RE: Intake Screening Review Additional Requests- Land Use

Permit No. 2108-244

Project Address: 12 Meadow Lane, Mercer Island, WA 98040

A1.0

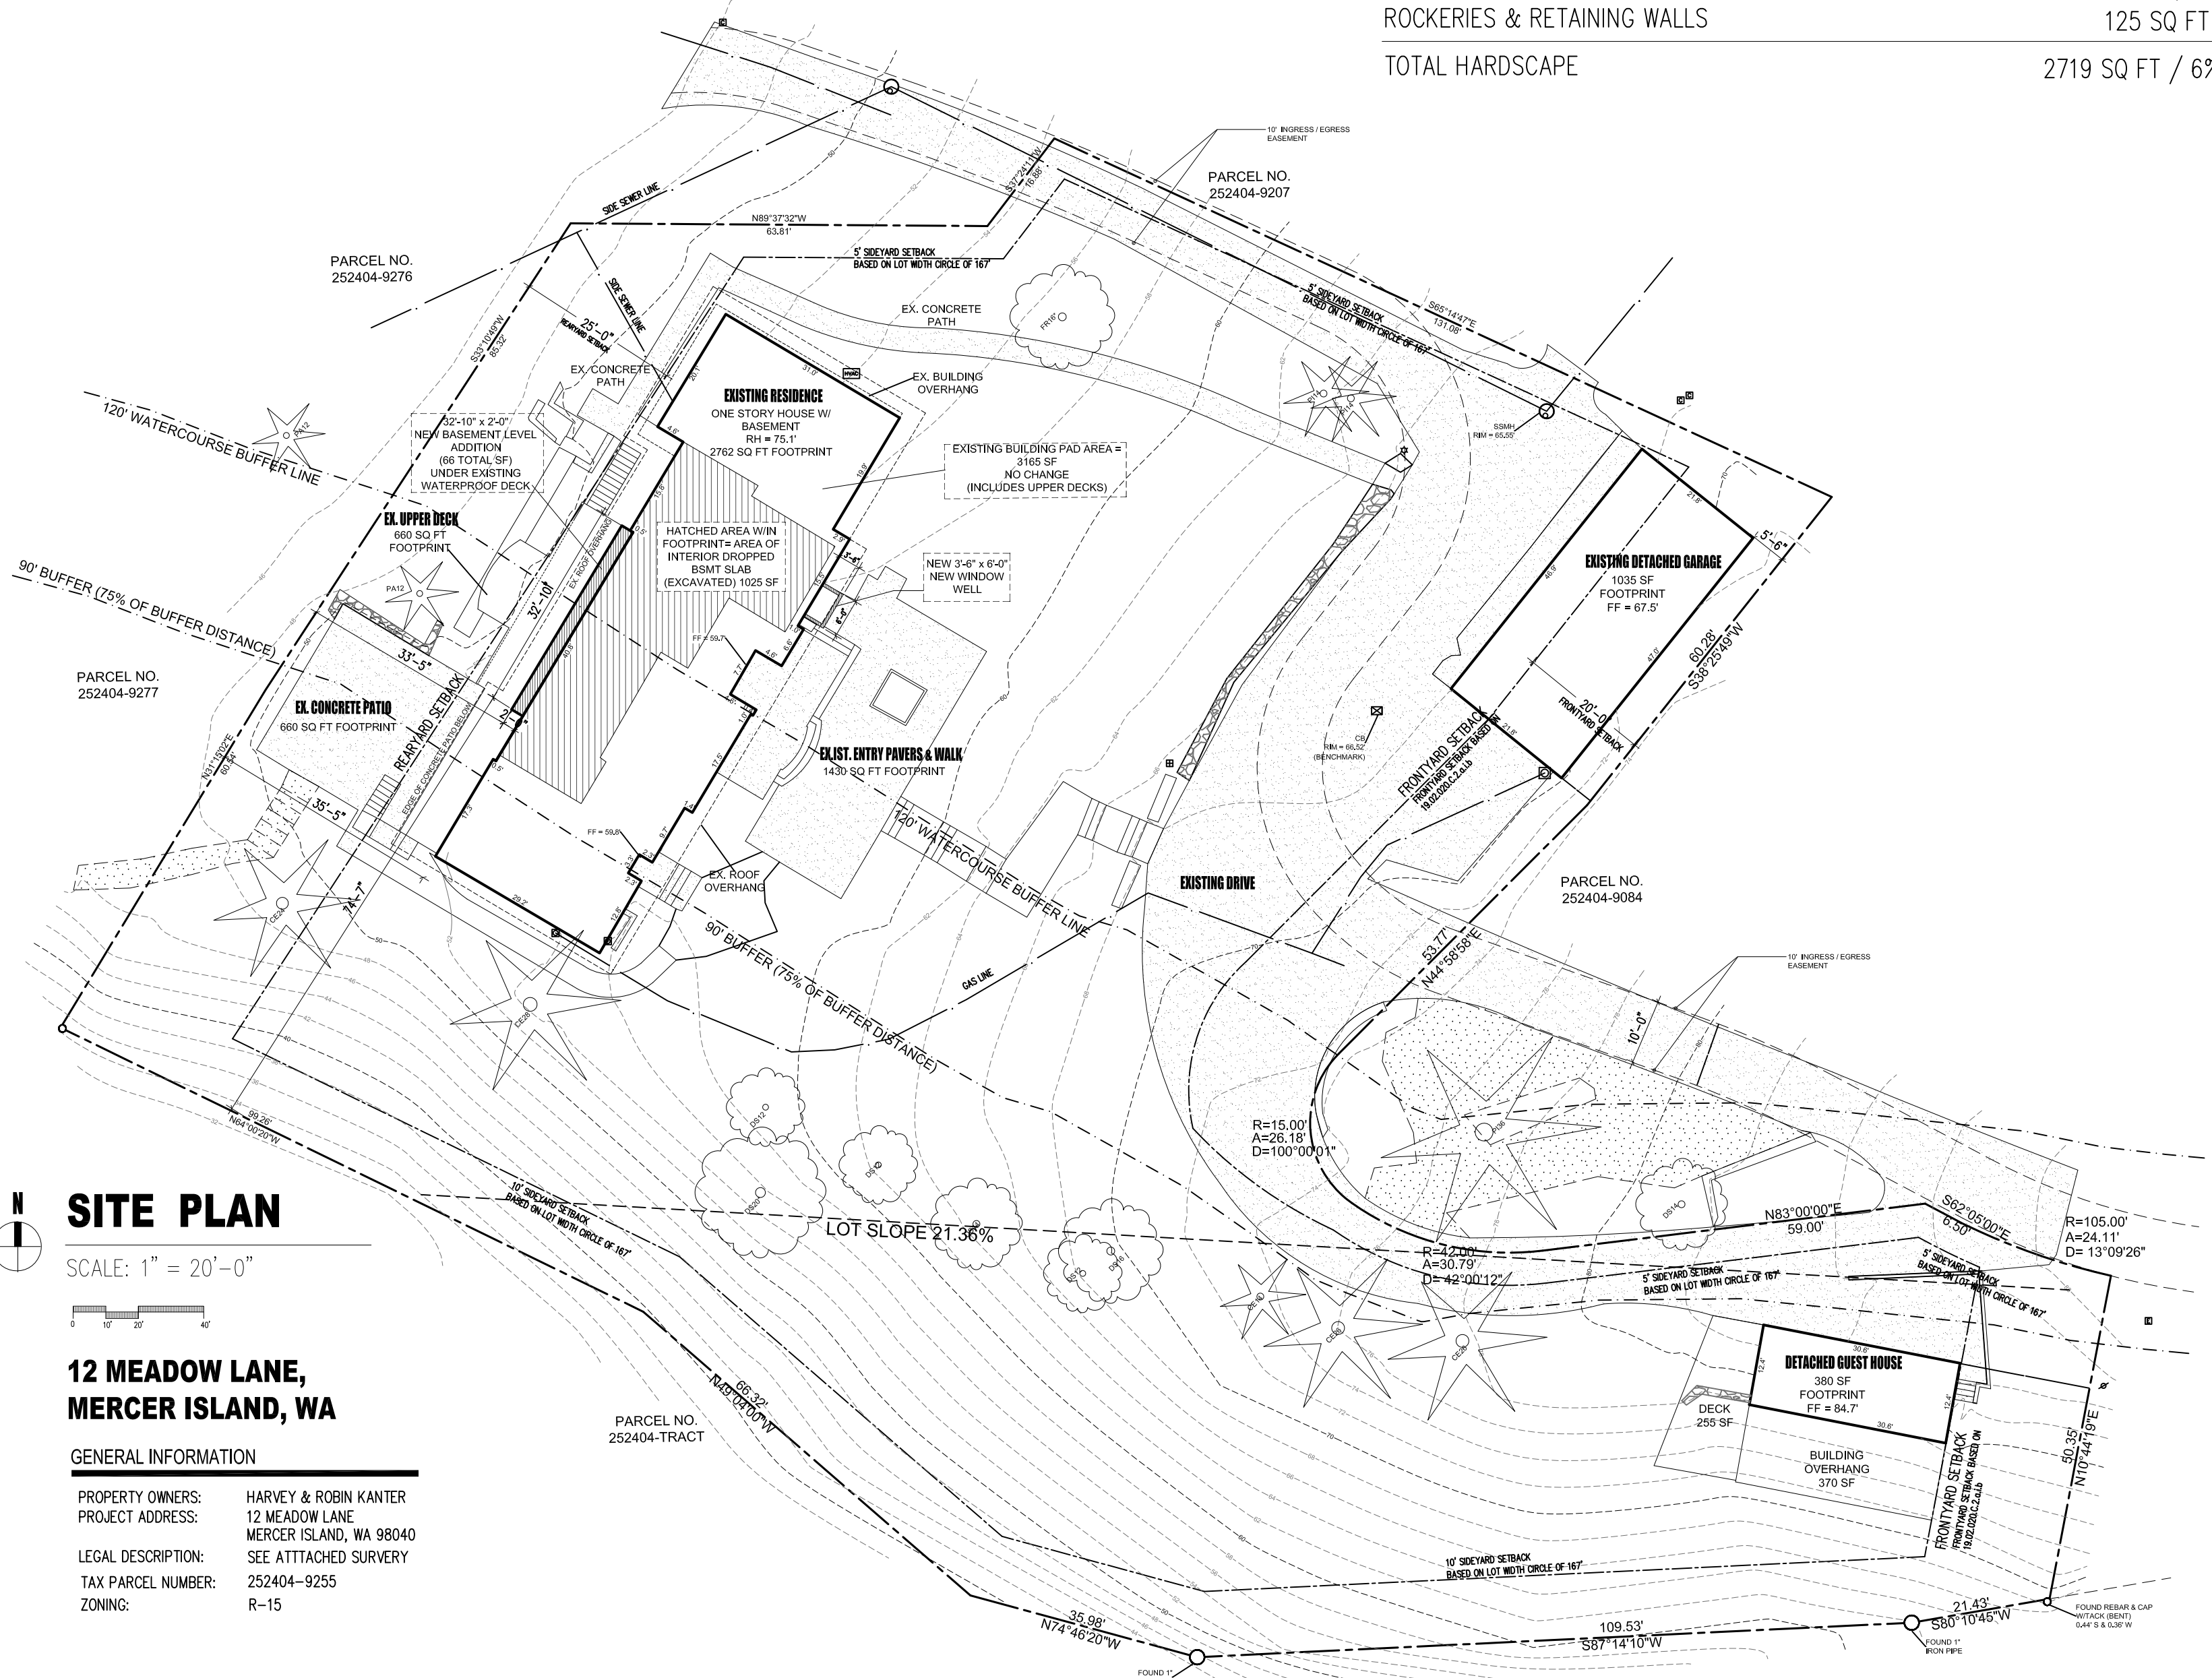
- Comment 3: We understand that we will need to do a Property Line Setback Survey at the completion of construction.
- Comment 4: See revised site plan, sheet A1.0 showing additional information. Per survey, I believe the only easement on the property is for a 10' wide road access. I have added a note to show where gas line and side sewer line fall. I have also added building pad area.

**A3.0**

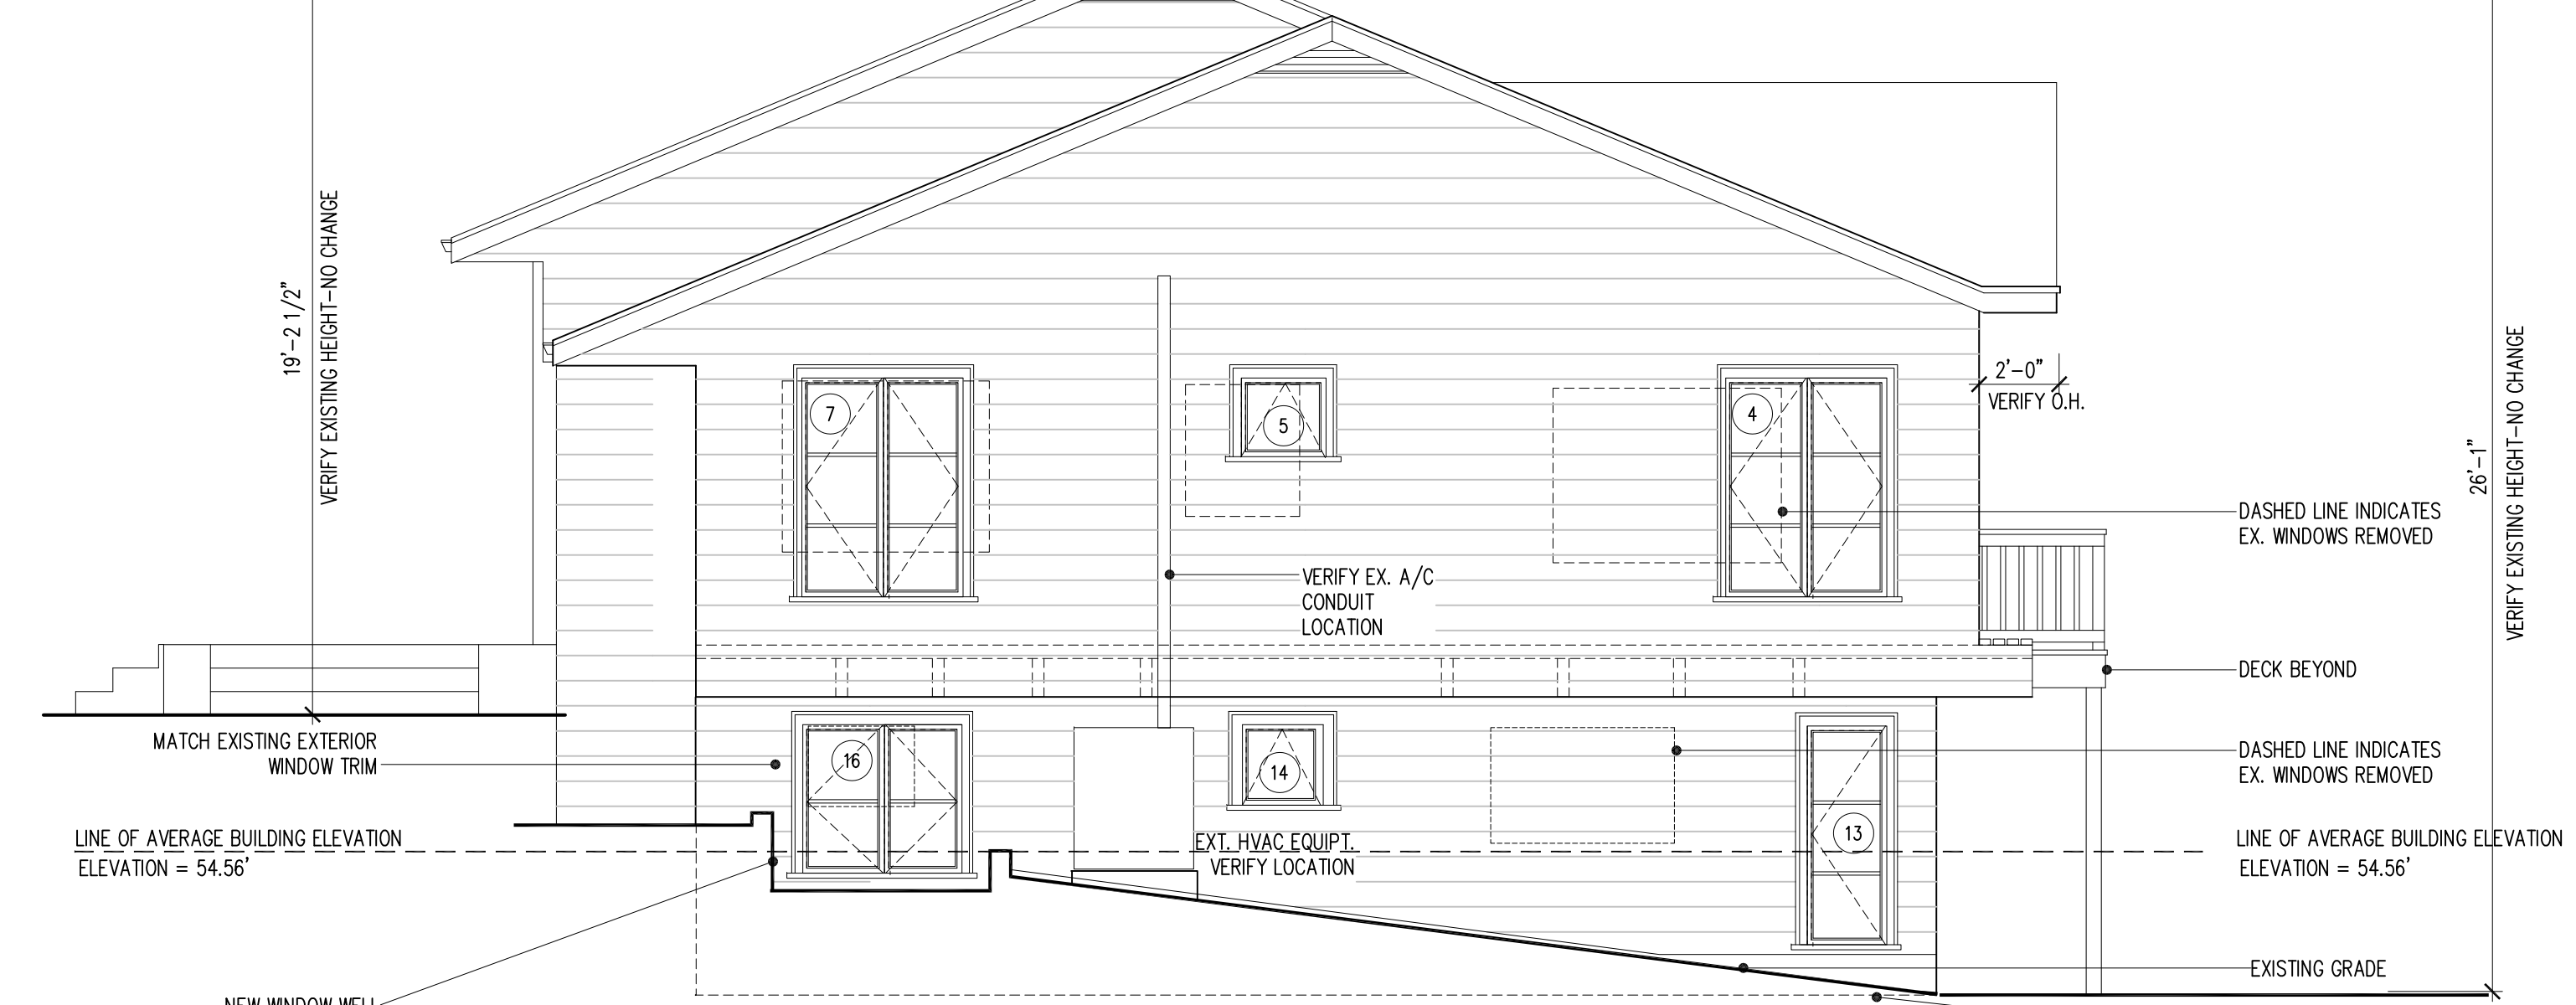
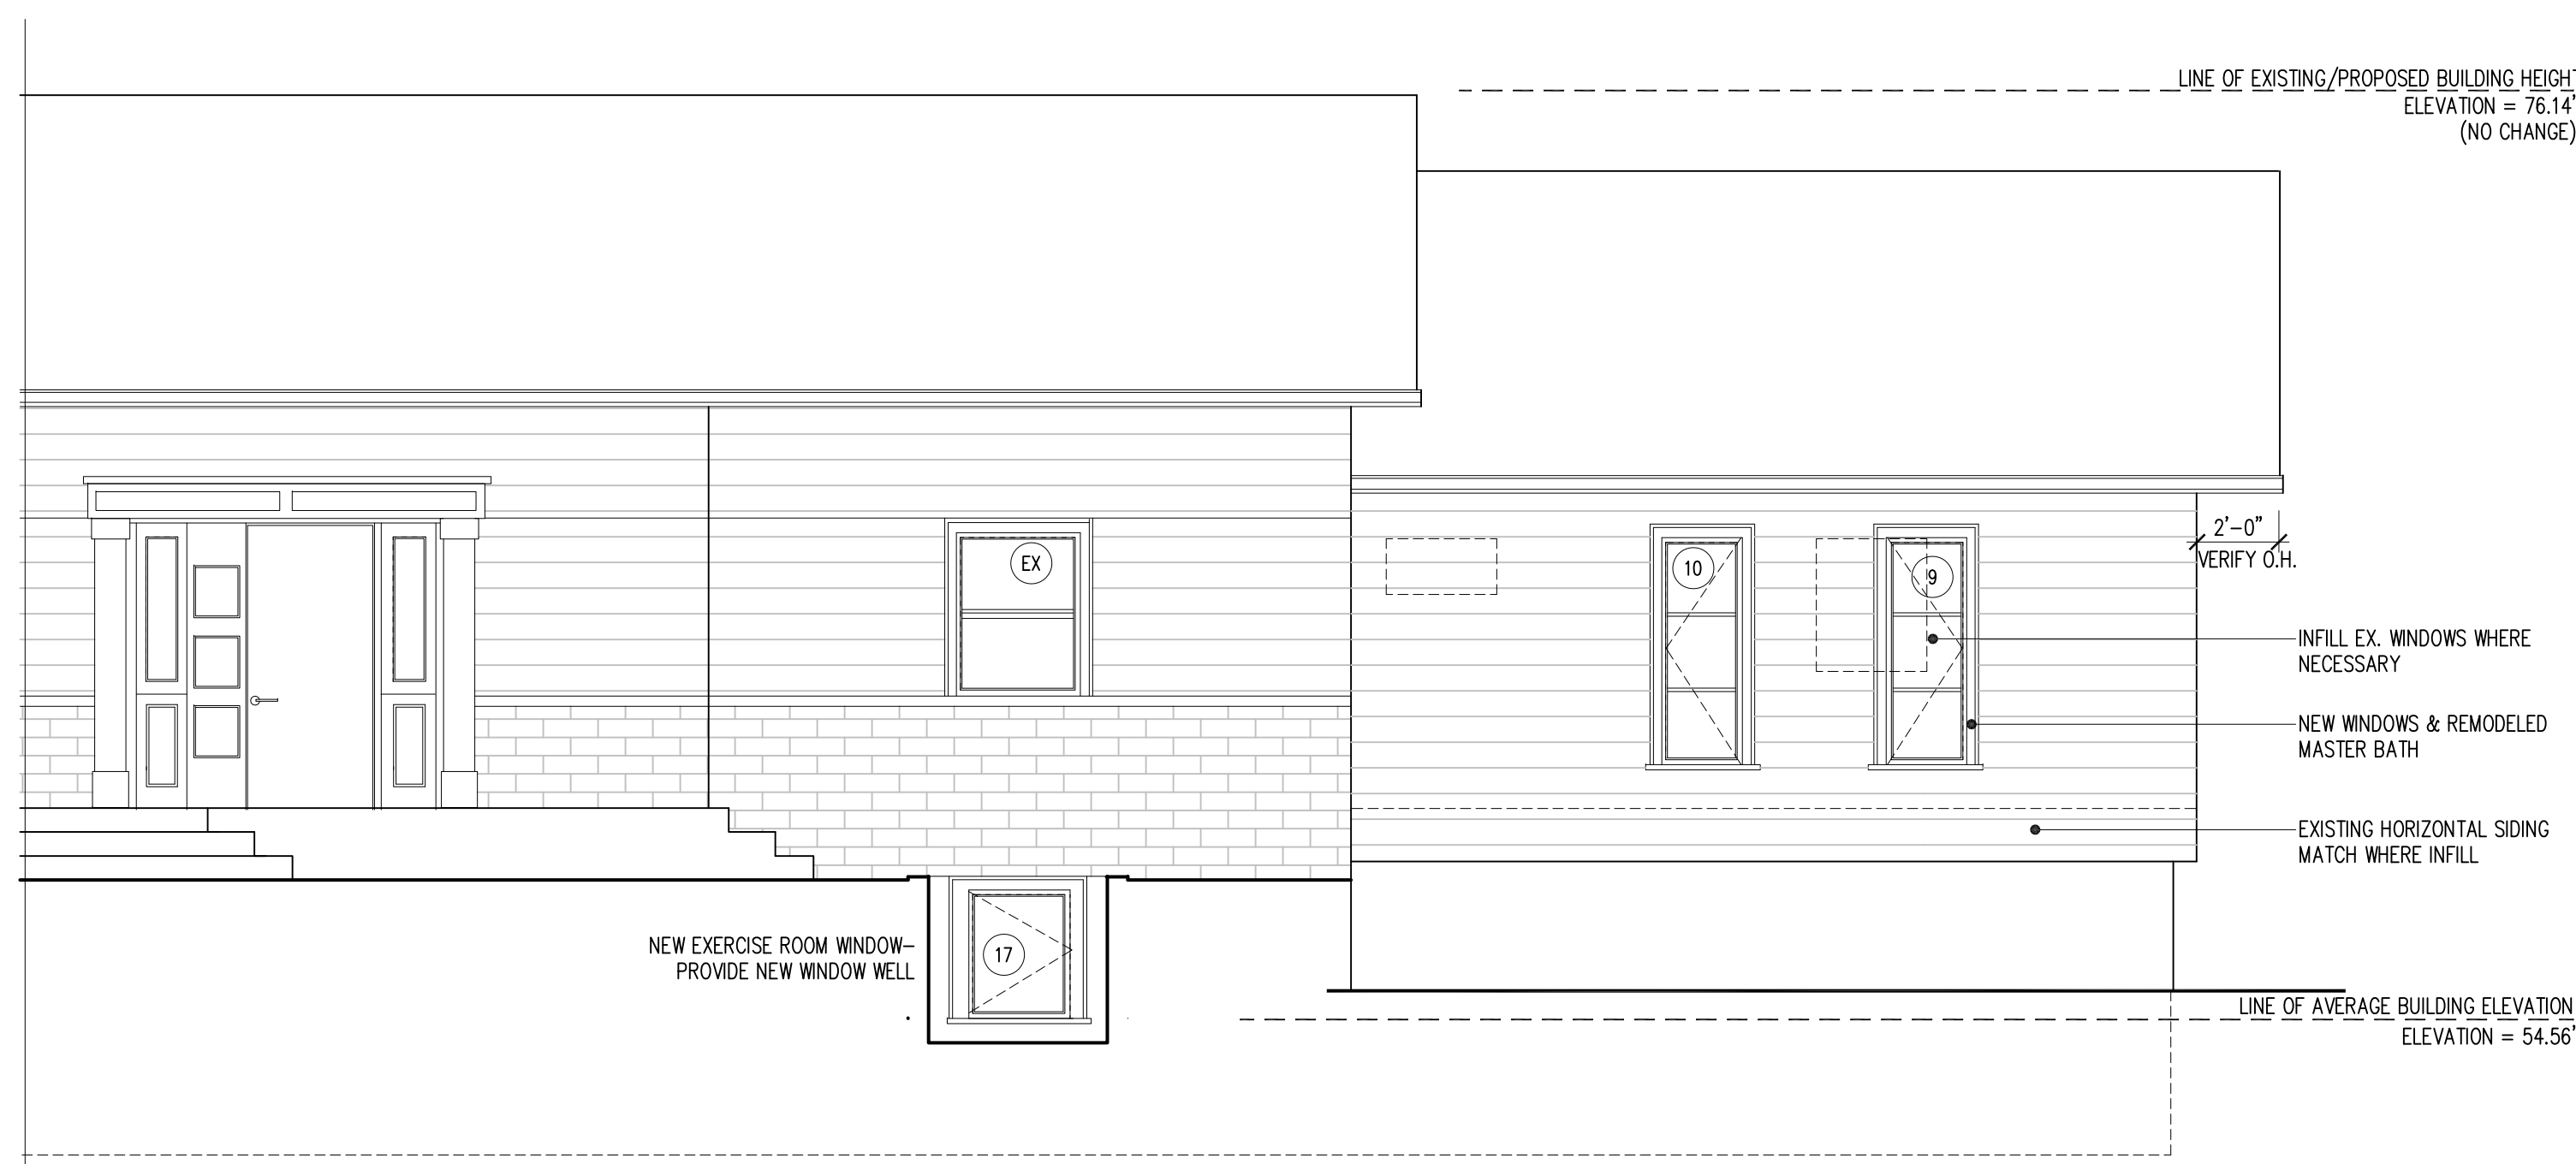
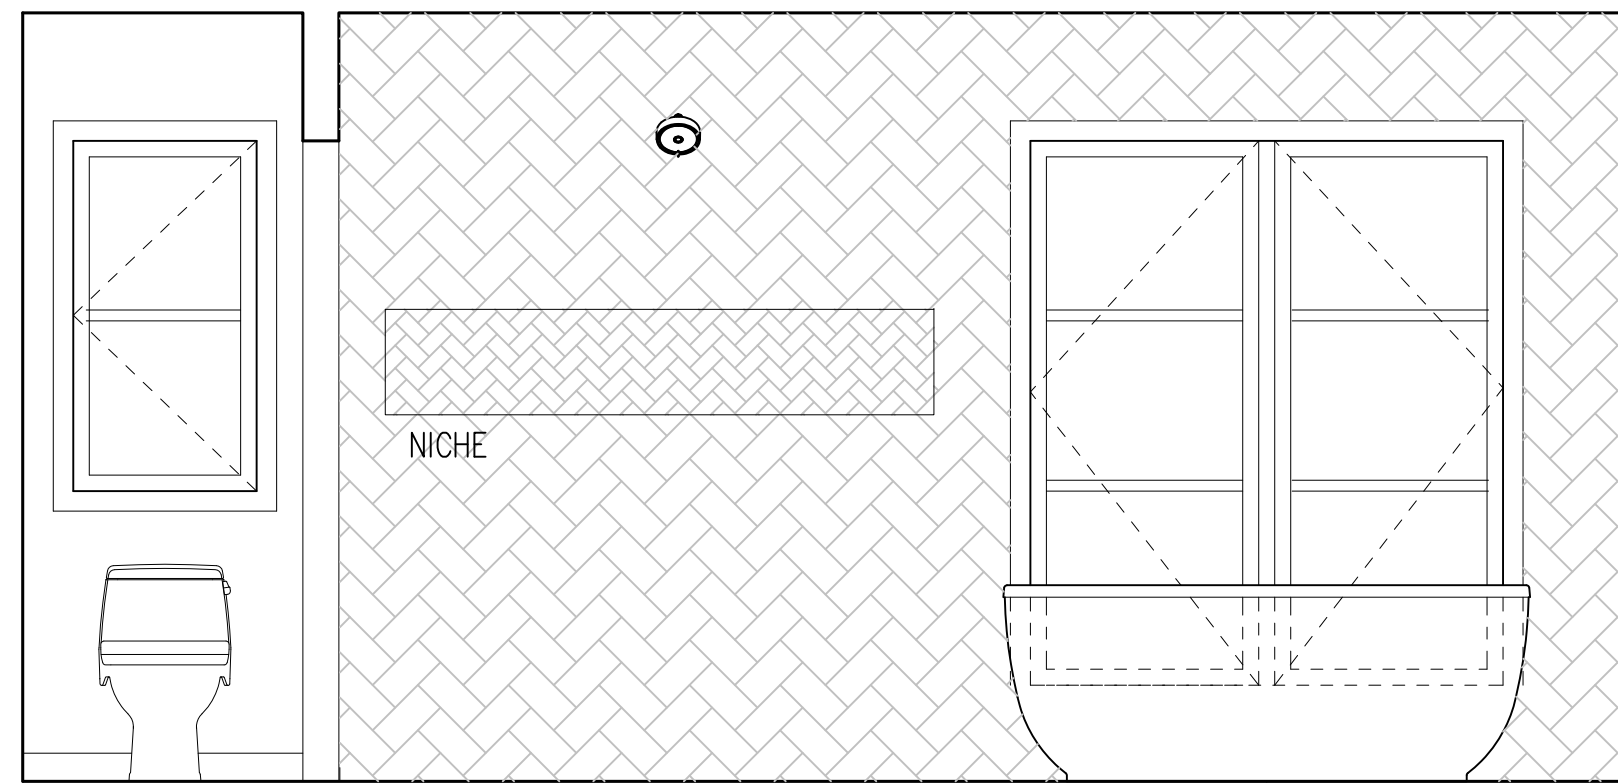
- Comment 5: Please see updated calculations for average building elevations on sheet A3.0.
- Comment 6: See Survey added to plan set submittal package, sheet 2 & 3
